FALCON ACRES EL PASO COUNTY CONSTRUCTION DRAWINGS AUGUST 2023

PCD FILING NO.: SF223

CONSTRUCTION PLANS
COVER SHEET

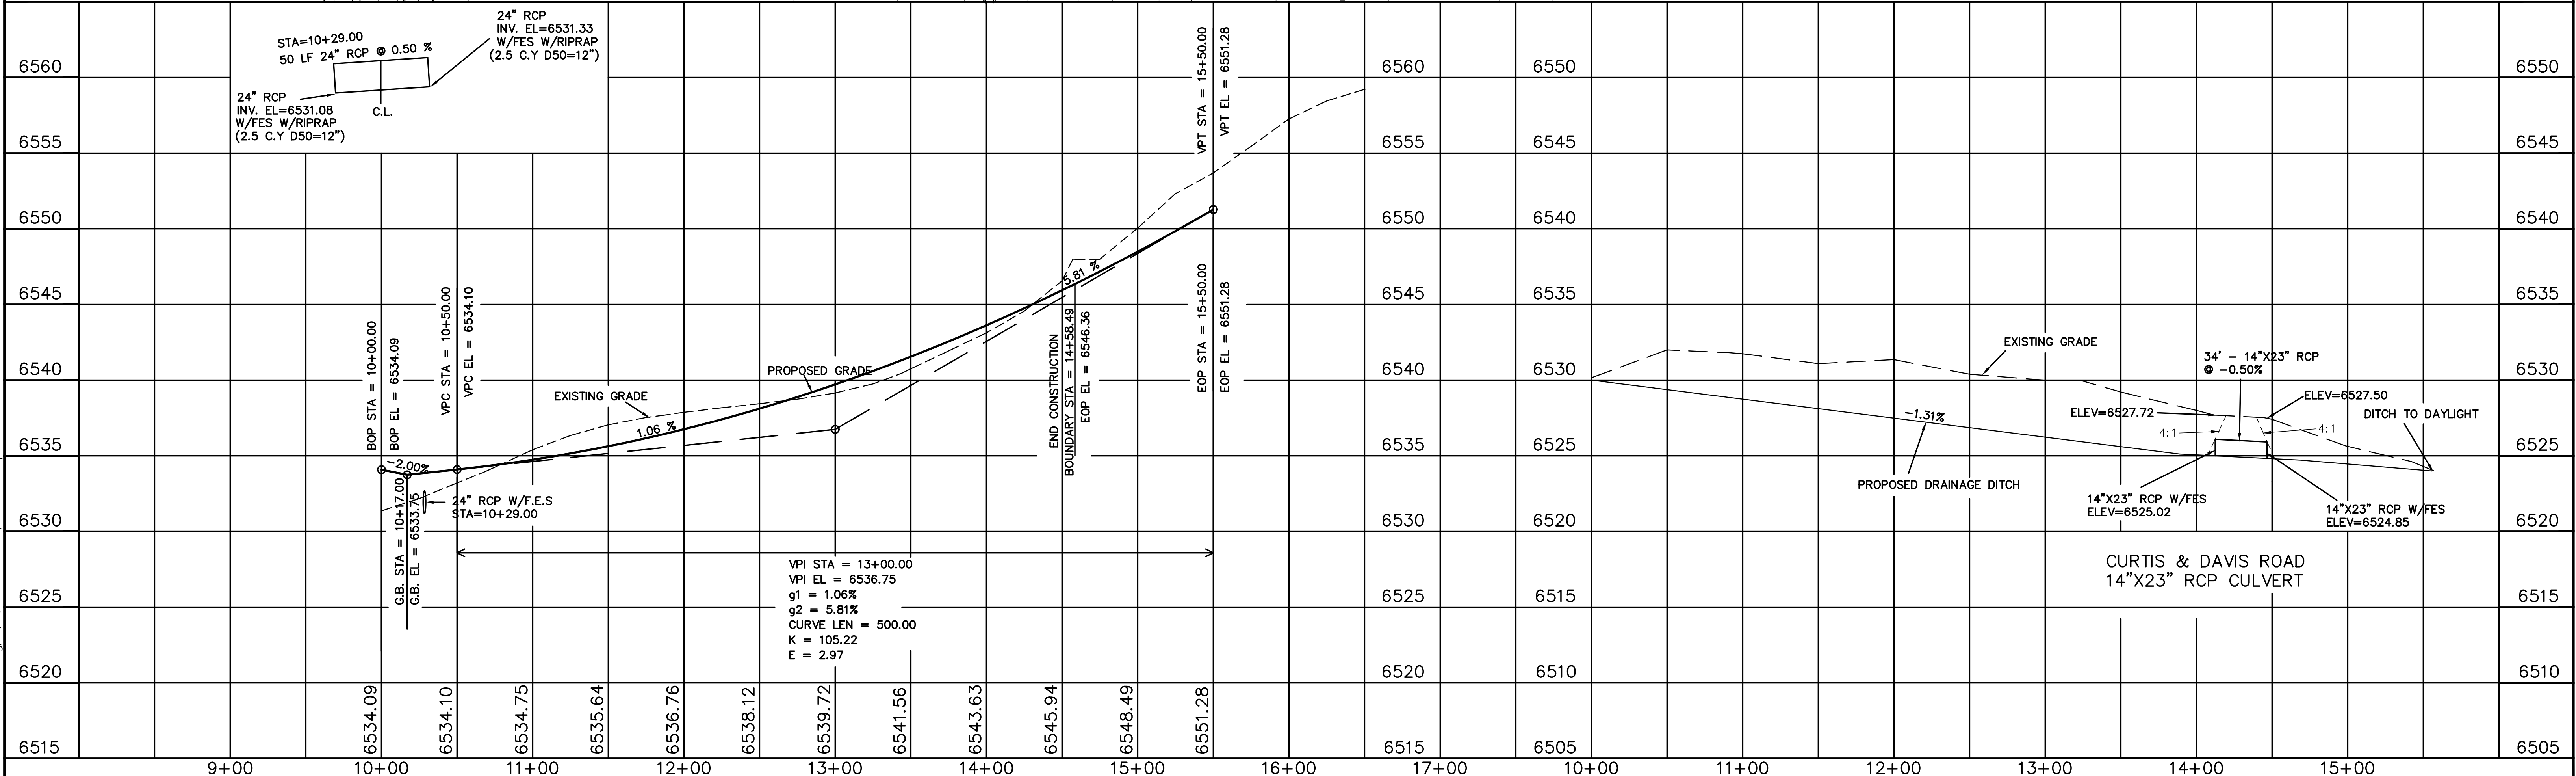
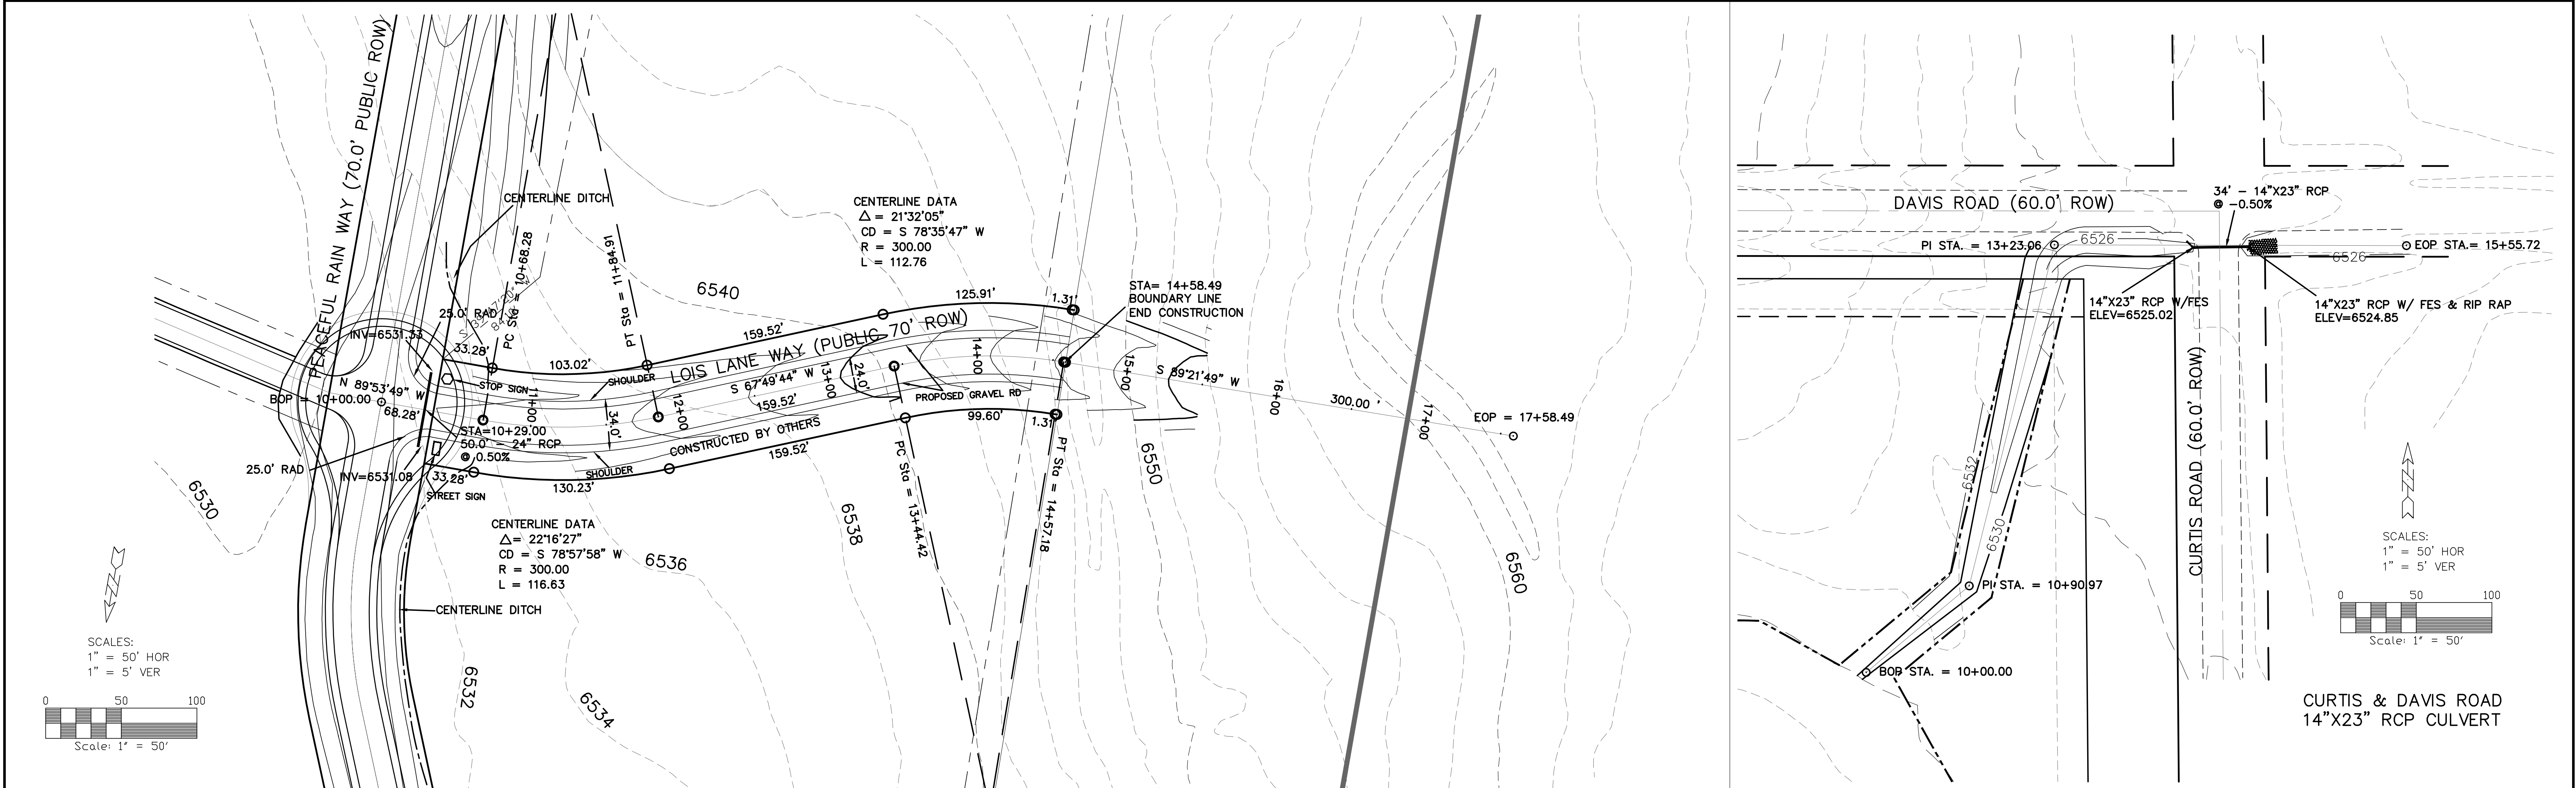
Add pipe separation design detail per V2 comment. Unresolved.

Culvert design has been modified to two parallel pipes therefore provide construction details for the required separation between the two culverts. CDOT detail M-601-12 shows minimum separation for the two pipes however this is with concrete headwall, not FES.

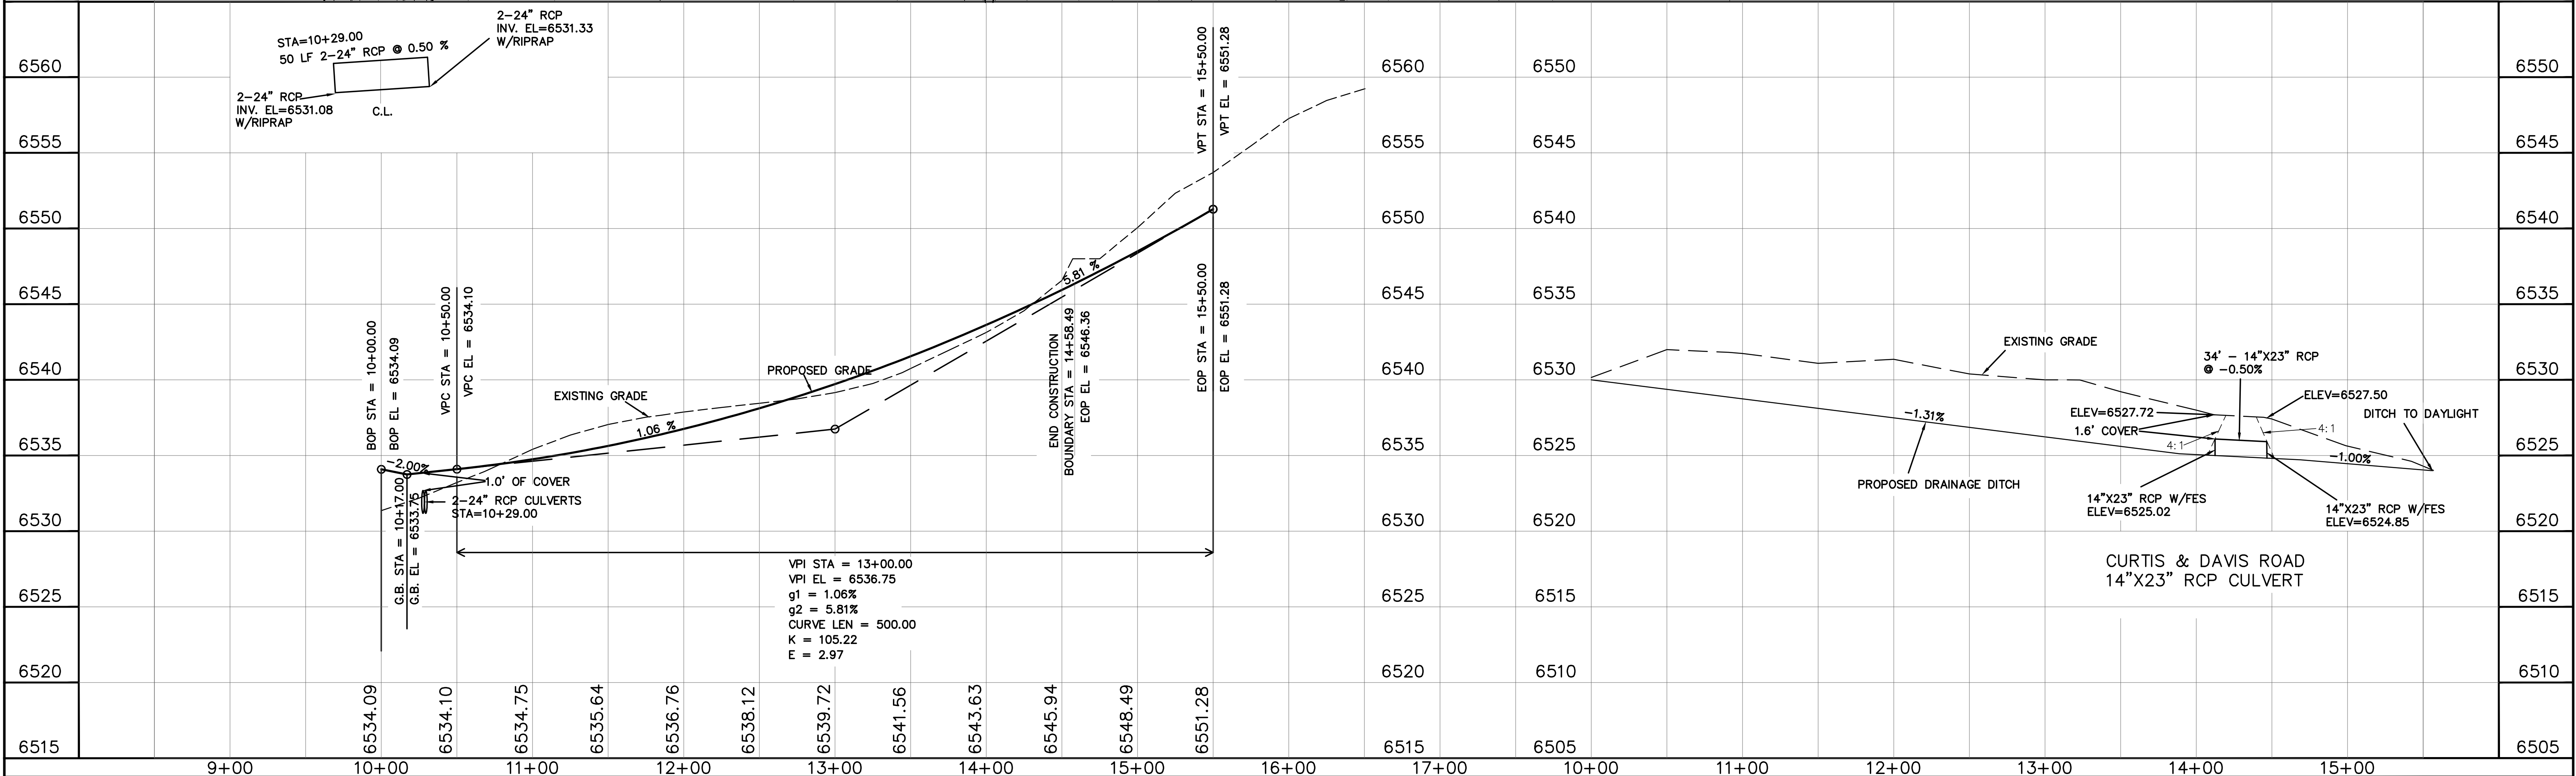
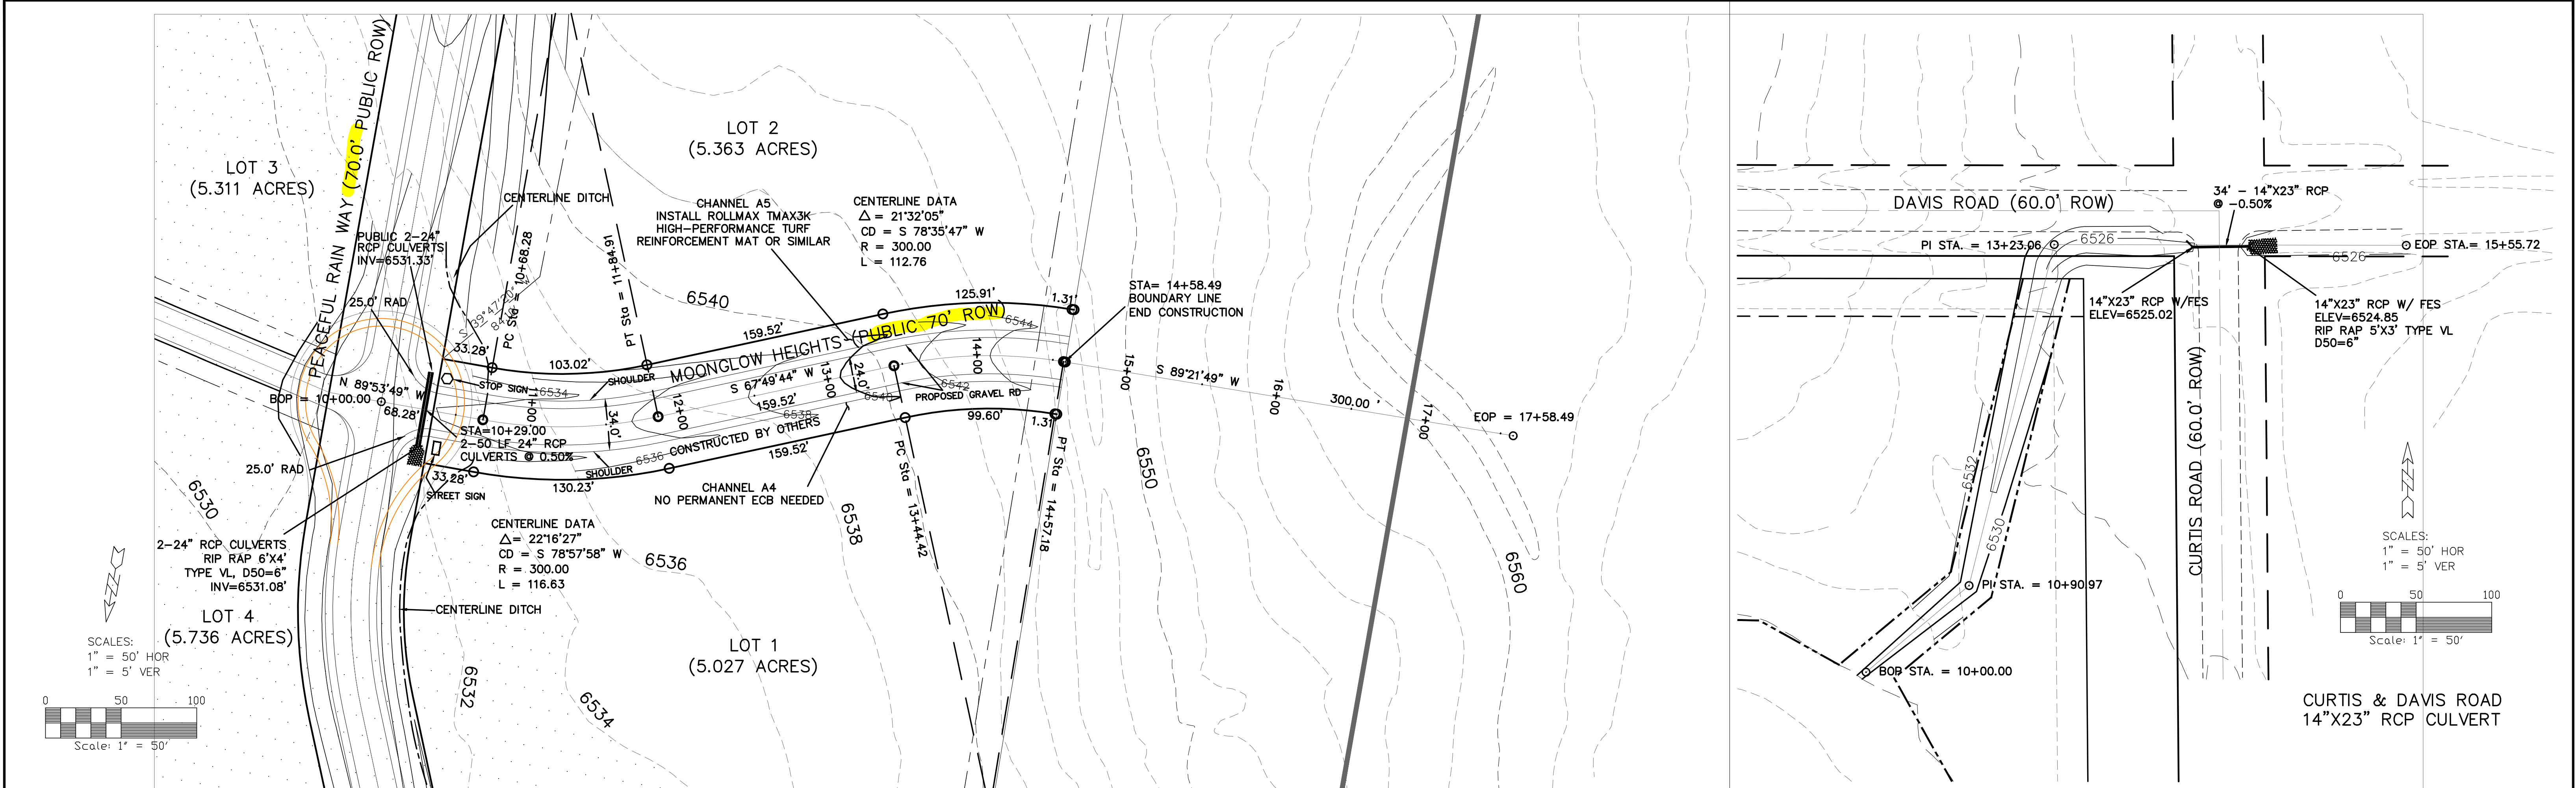
Ensure all ROW widths are consistent 60ft ROW with x2 5ft easements

These travel lanes need to be 12ft. Call out and show road shoulder width
